March 10, 2005

RE: PROP, 131 – 133 Anderson St. Portland, ME  
CBL: 012 B0- 09

We've reviewed the list of comments on the submitted plans and listed below where the information is located, or what our proposed solution will be. Once reviewed and approved we will assemble an Addendum to incorporate the revisions as necessary. I've also attached your letter for easy reference.

1 TYPICAL PENETRATION
SCALE: 6" = 1'-0"

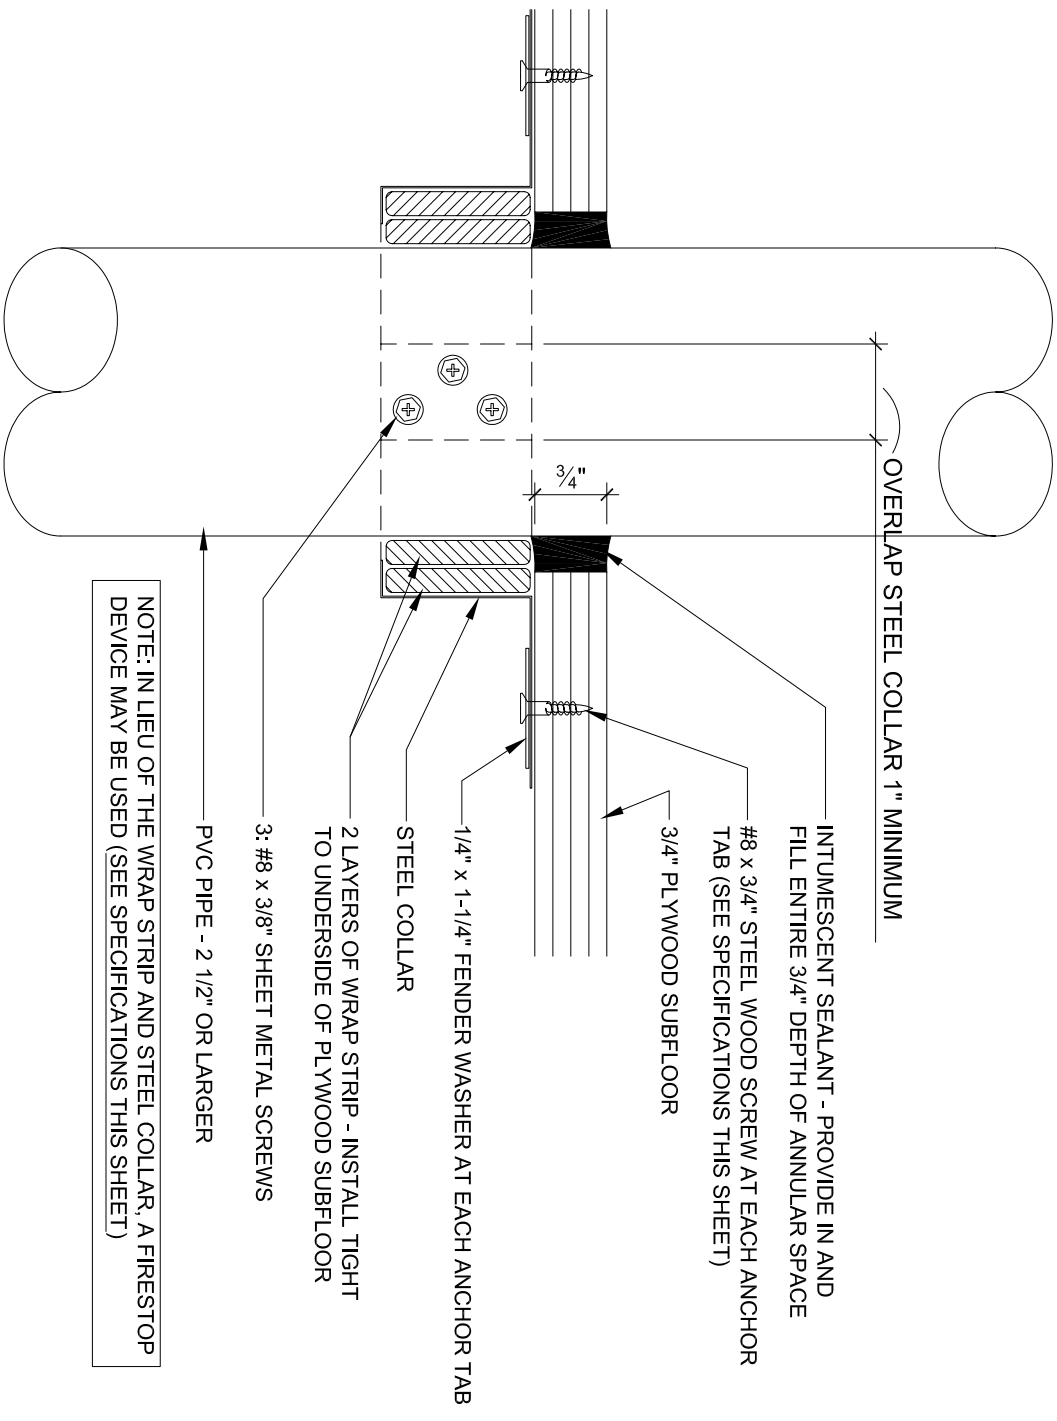
8. Sheet M1.0 indicates typical mechanical fire penetrations. I have also attached the typical fire penetration detail we use when not covered by the Mechanical typical details. We will incorporate this into the documents. The intent for all the routing of dryer, bathroom & kitchen exhaust is to directly exit the building in as short a route as possible through the unit serviced. There should not be any instance of exhaust entering the shaft. If at any point a duct penetrates a rated assembly on its route to the exterior, we will install an appropriate fire damper.

A4.1

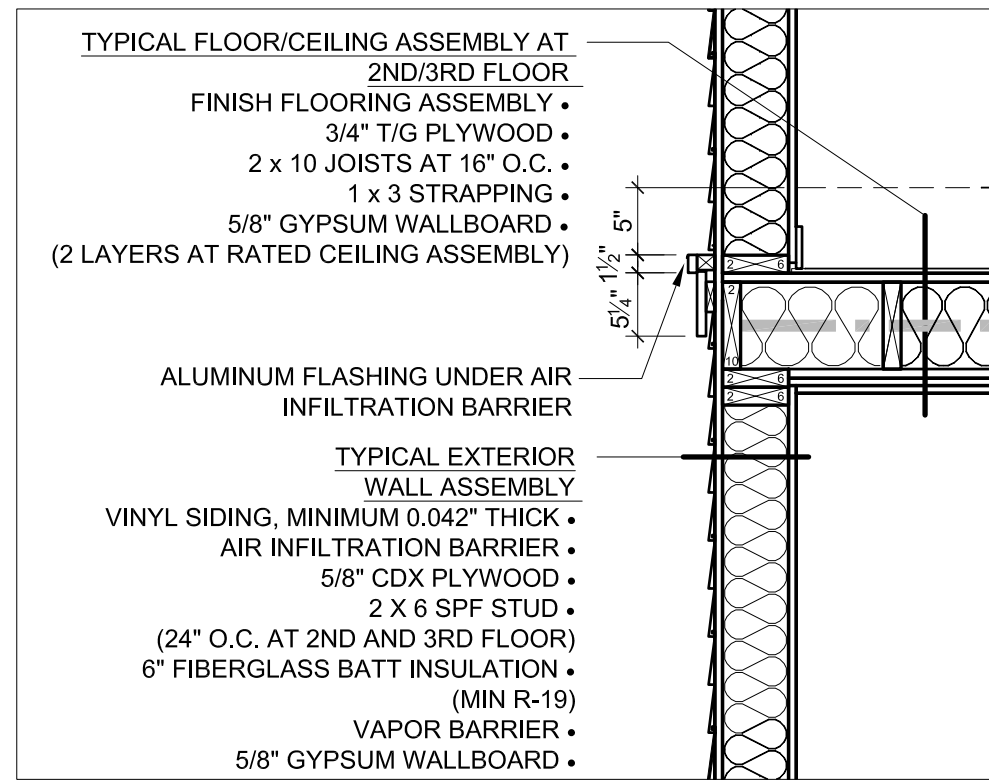
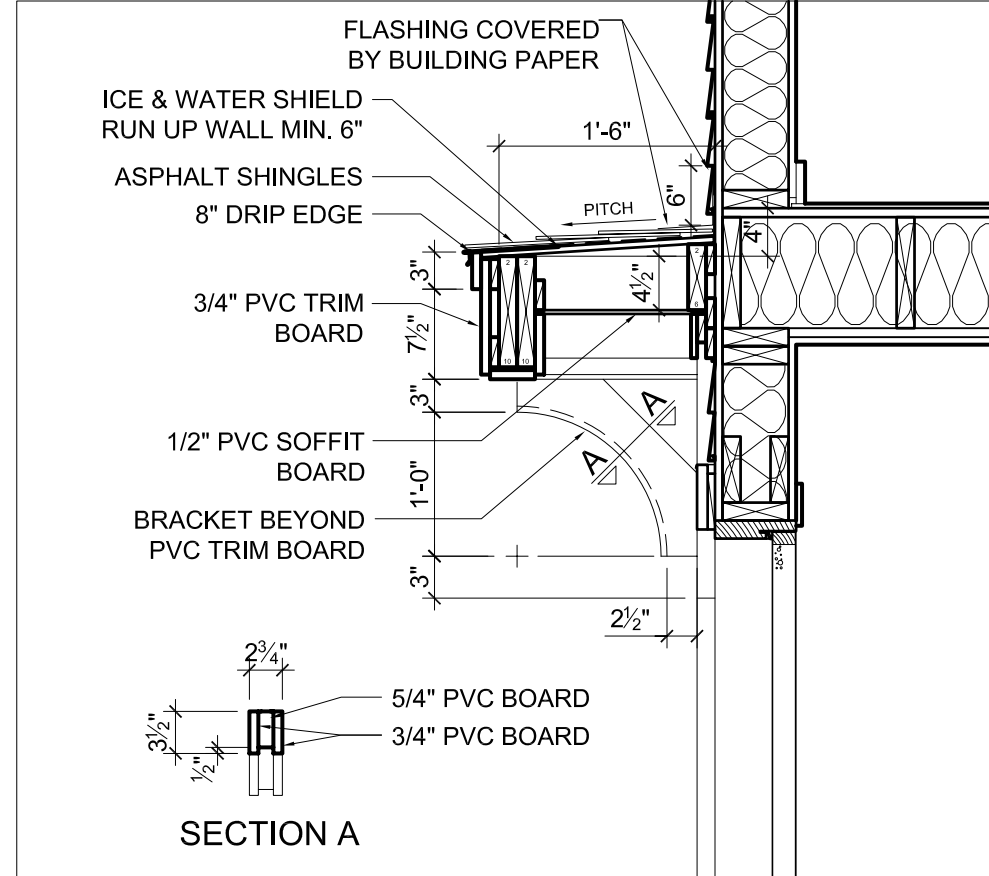
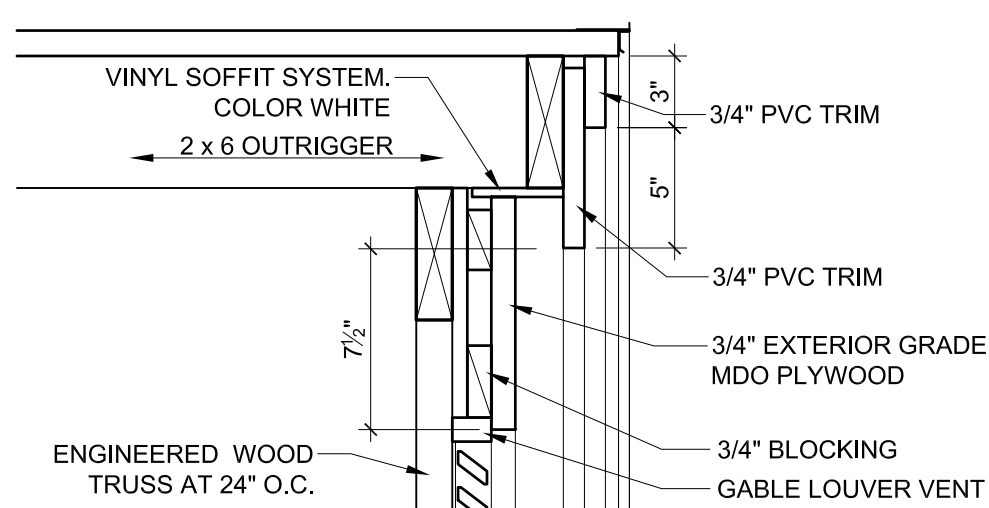
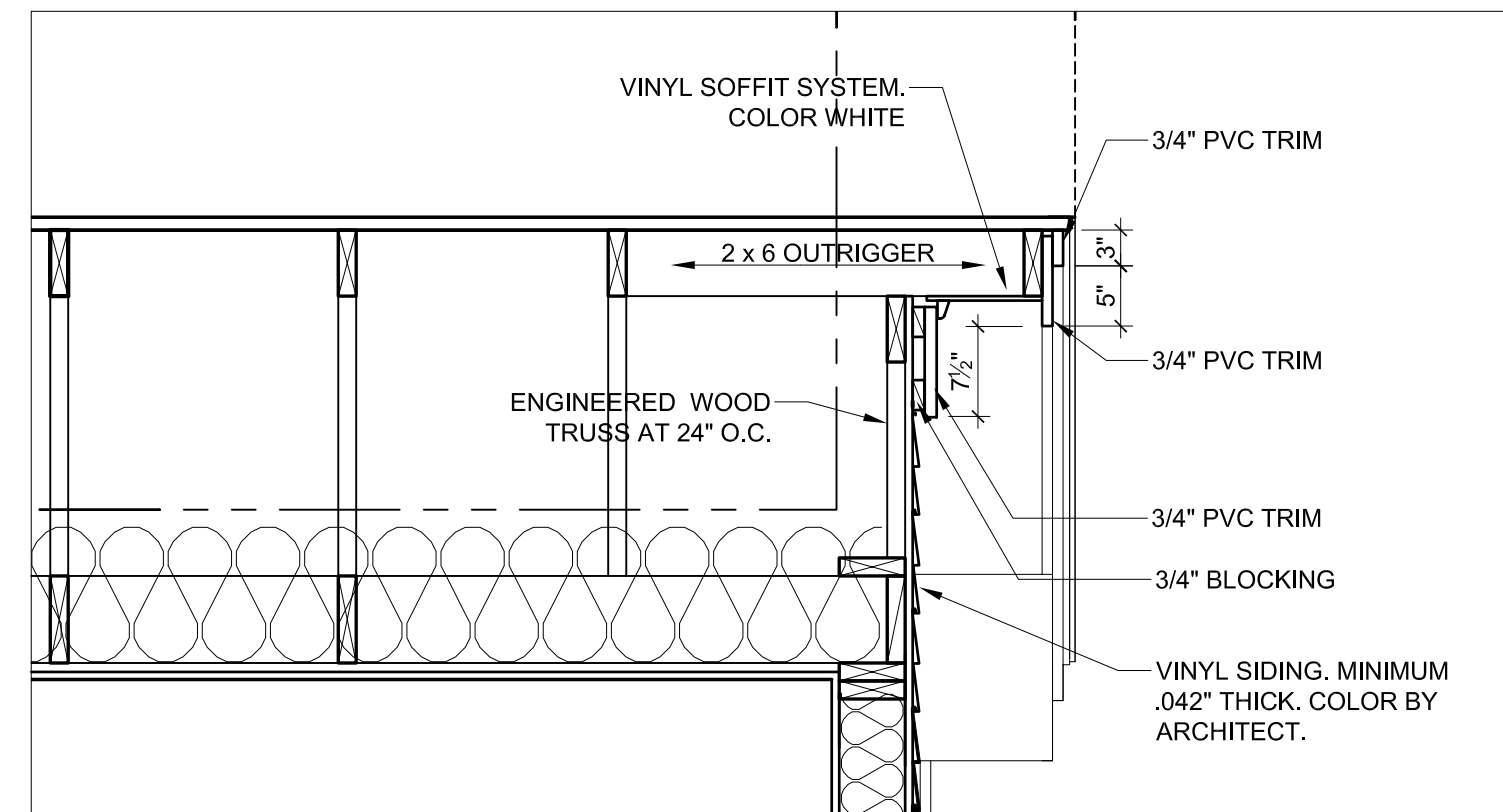
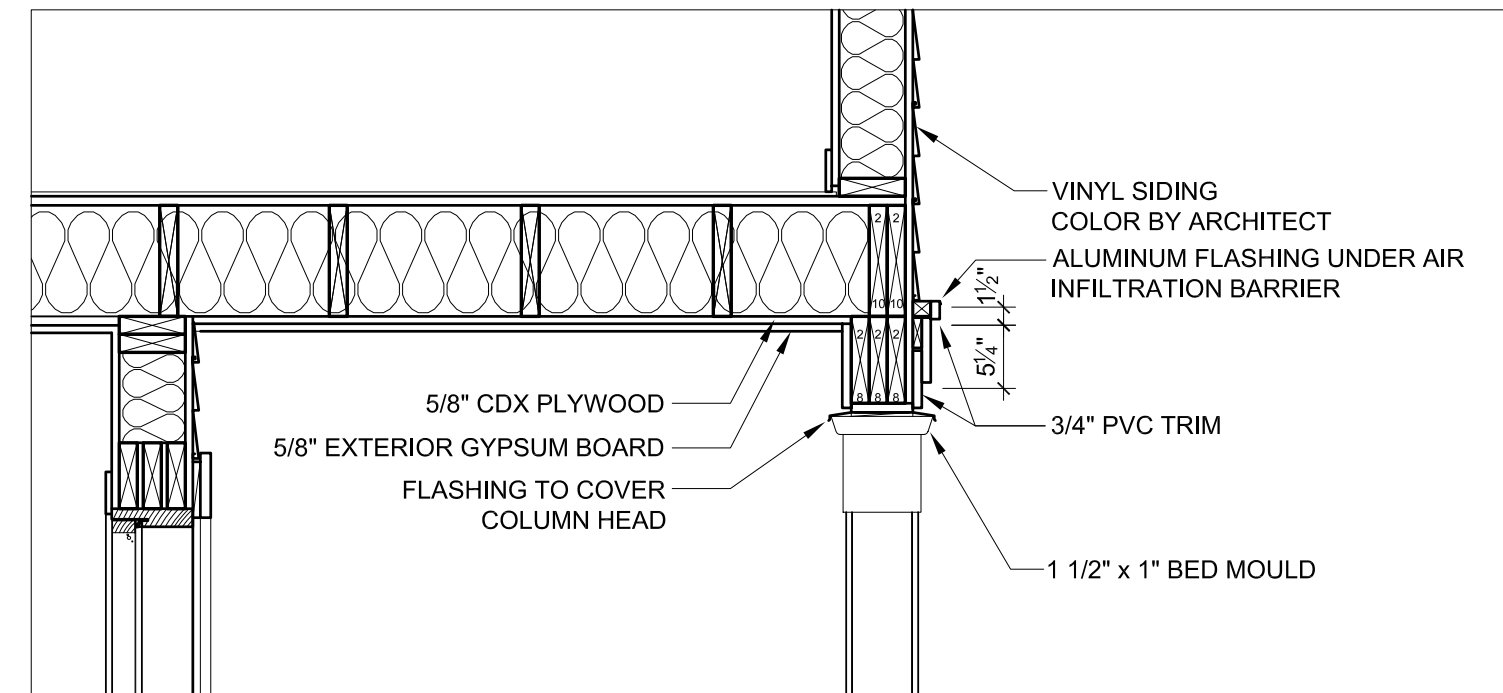
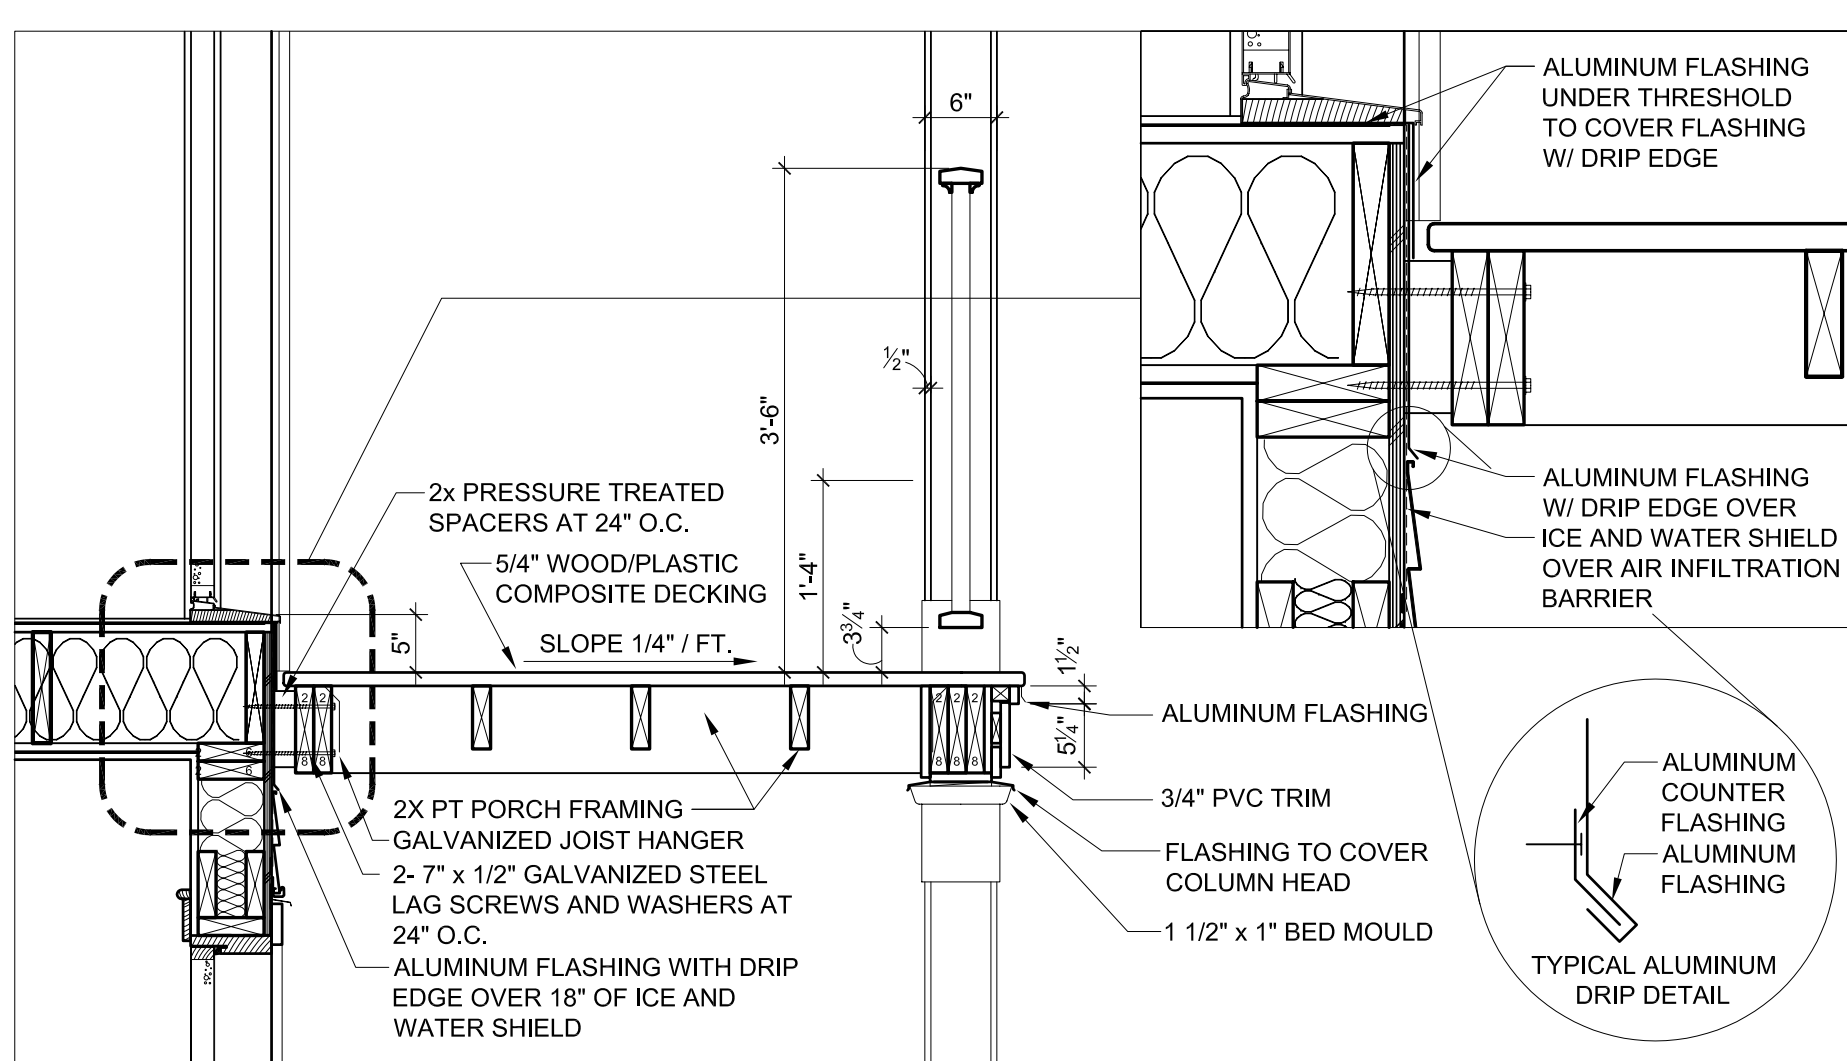
- c. Please see attached memo from Dave Tetreault of Structural Design Consulting regarding shear design. Wall sections are included on sheets A4.0 & A4.1 and are thoroughly noted; if there is additional information you require, please let us know.
